**Consultation Response from KC,
Trees****2025/93540 adj, Clough Hey, Manchester Road, Marsden, Huddersfield, HD7 6DW****Erection of 1 pair of semi-detached dwellings (within a Conservation Area)****Date Responded: 19/01/2026****Responding Officer: JD****Responding Ref: 27/17**

The site is situated within Marsden Conservation area and there are TPO'd trees present on and adjacent the site (TPO 27/17).

**Appendix 5: Tree Protection Plan**

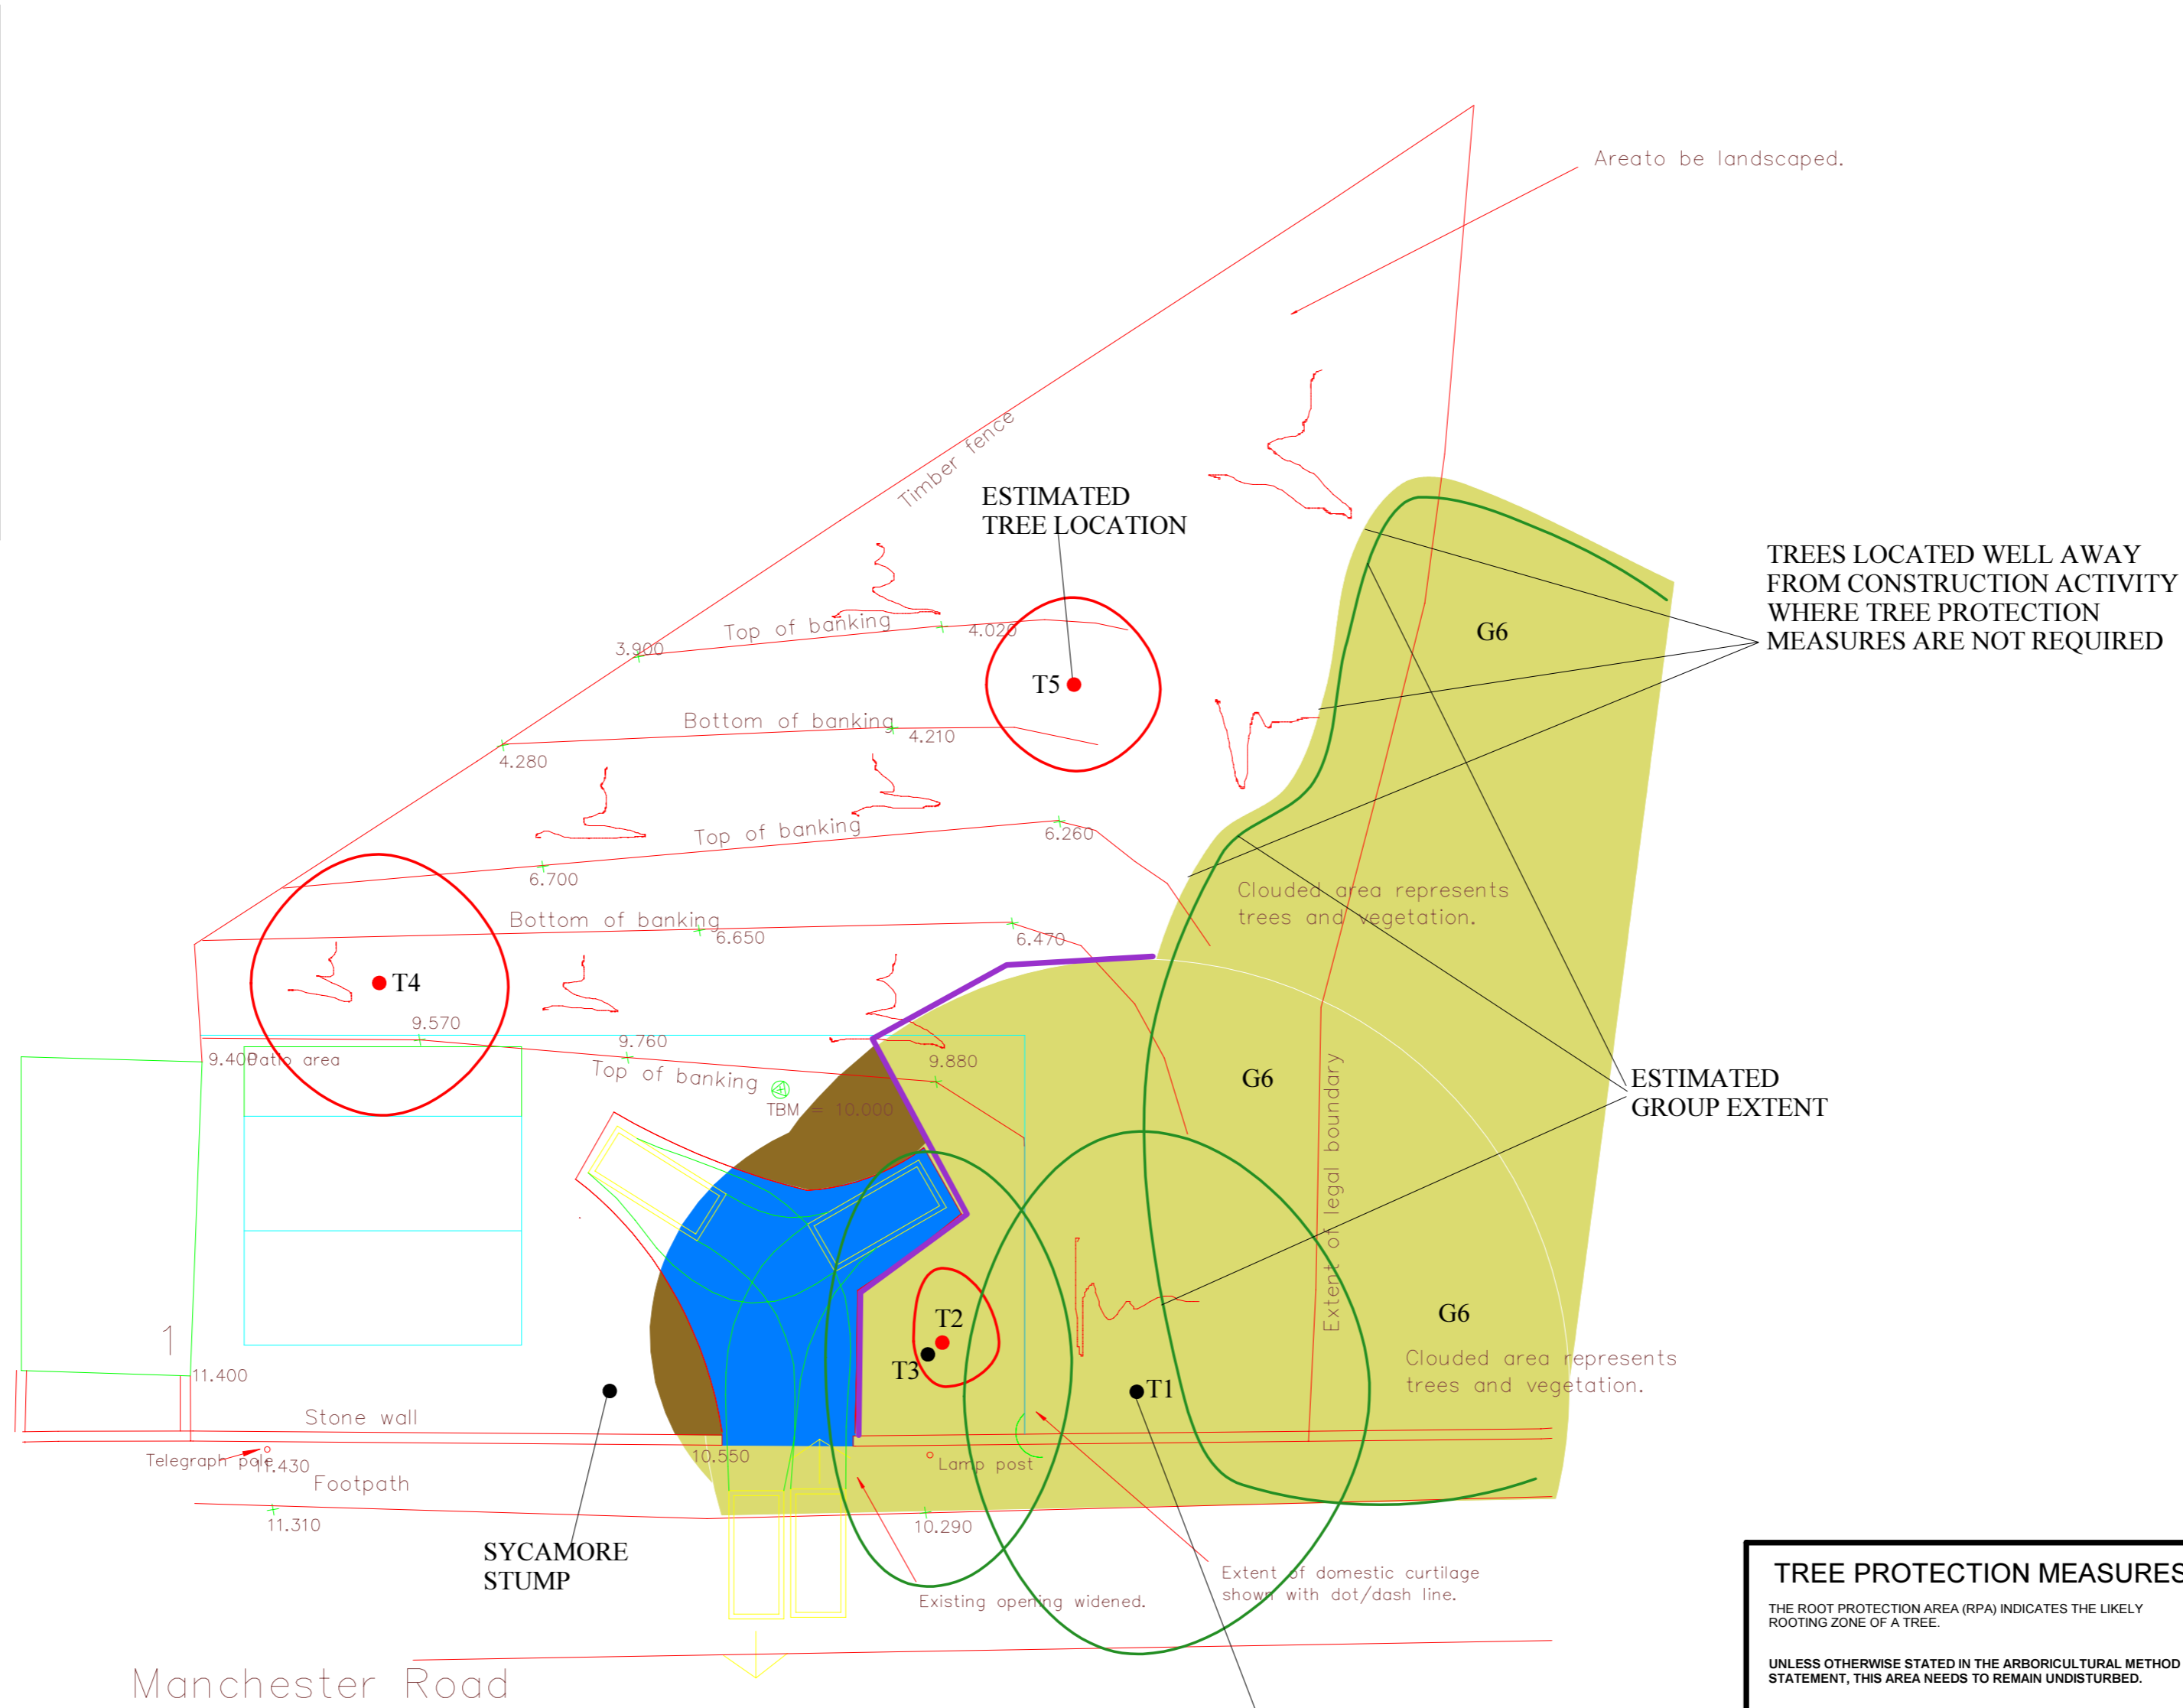
The building of the dwellings looks achievable with the removal of tree T4 (as mentioned in the Arboricultural Method Statement). This would be deemed a tolerable loss due to the trees category C status. However, the proposed driveway/turning circle is situated directly adjacent tree T3 and T1, both are protected by TPO. Even with the proposed no dig construction and cellular confinement system KC trees deems the works to be too close to T3's stem and to cover approximately 50% of the trees Root Protection Area which would have a direct impact on the trees future viability as well as indirect impact going forward due to pressure to have the tree worked on to alleviate issues such as leaves and honey dew dropping on vehicles.

Permanent hard surfacing should not exceed 20% of any existing unsurfaced ground within the RPA of protected trees and the proposals clearly show a larger percentage than this. The amount of traffic and use this area will receive due to construction is likely to be large as well as the continued use as a parking bay.

Site plan (1:200)

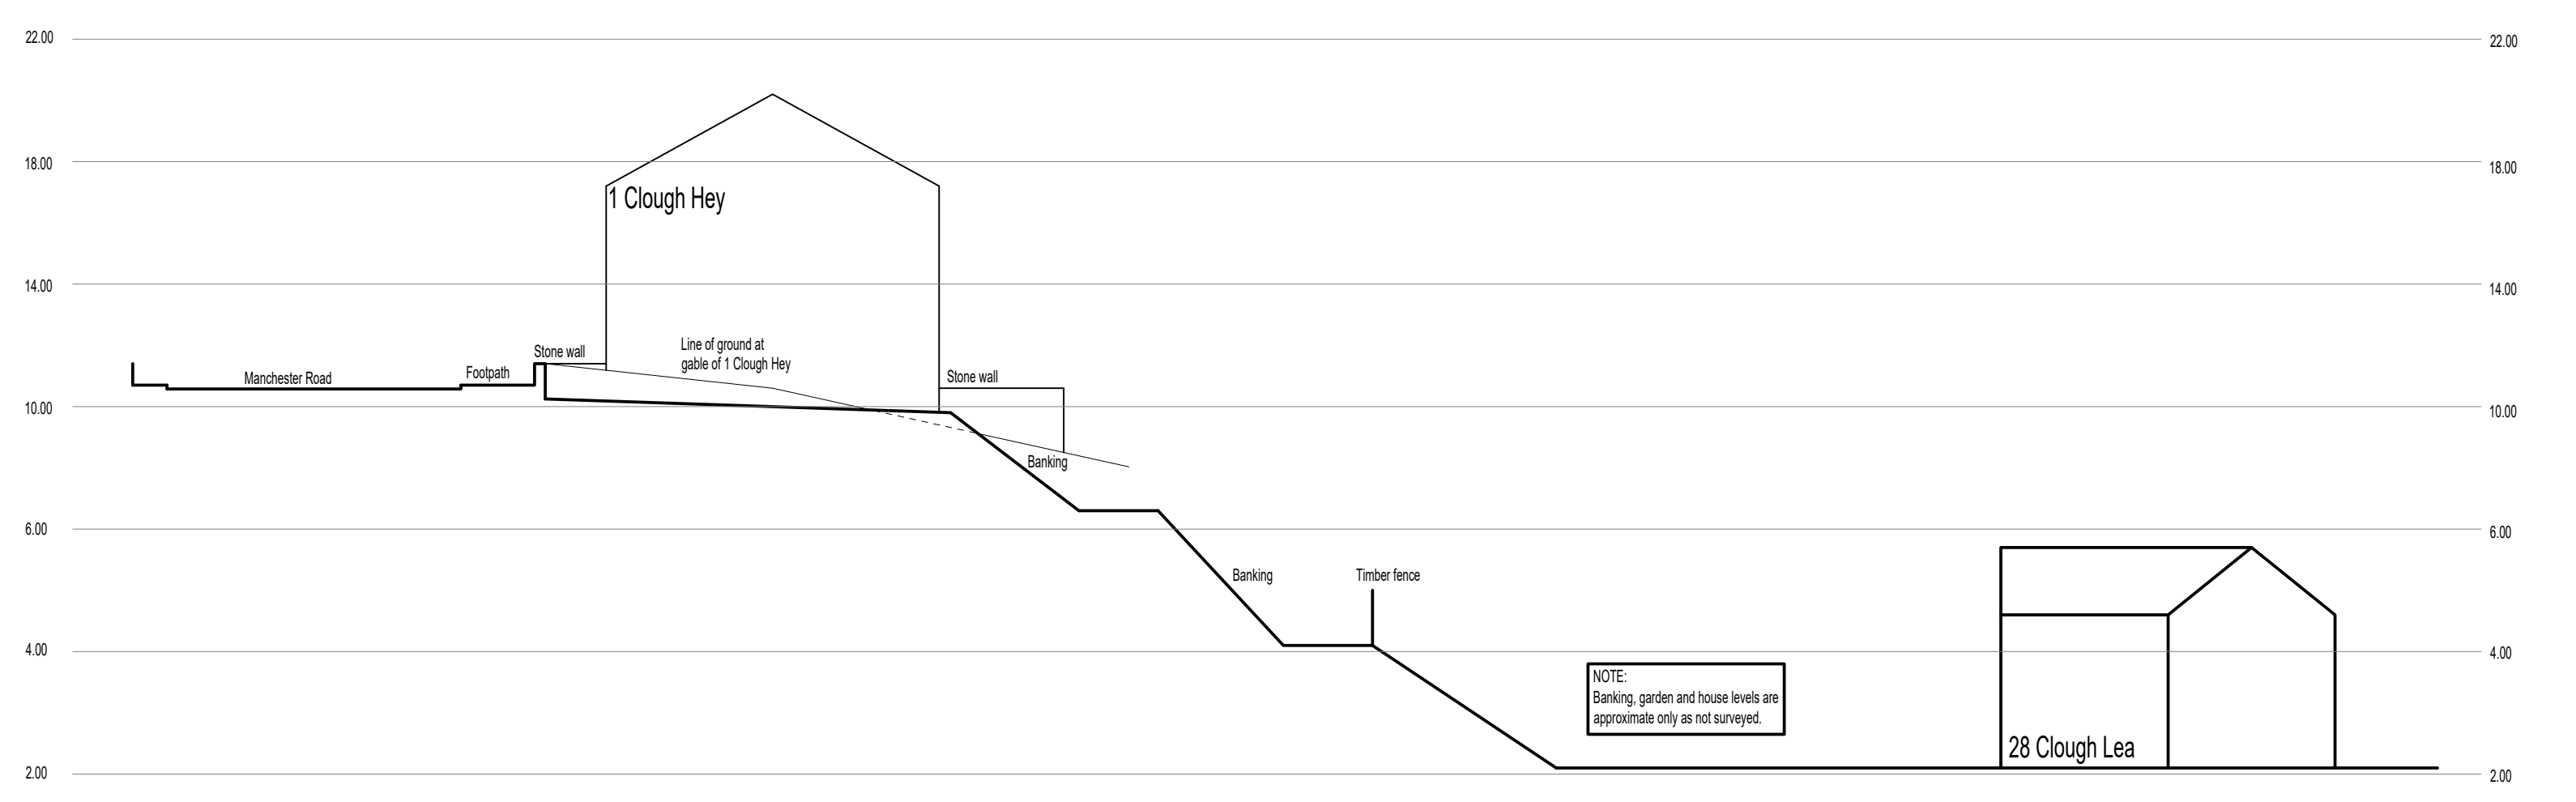
There is an objection to the proposals as they currently stand due to the proximity to protected trees roots and stem.
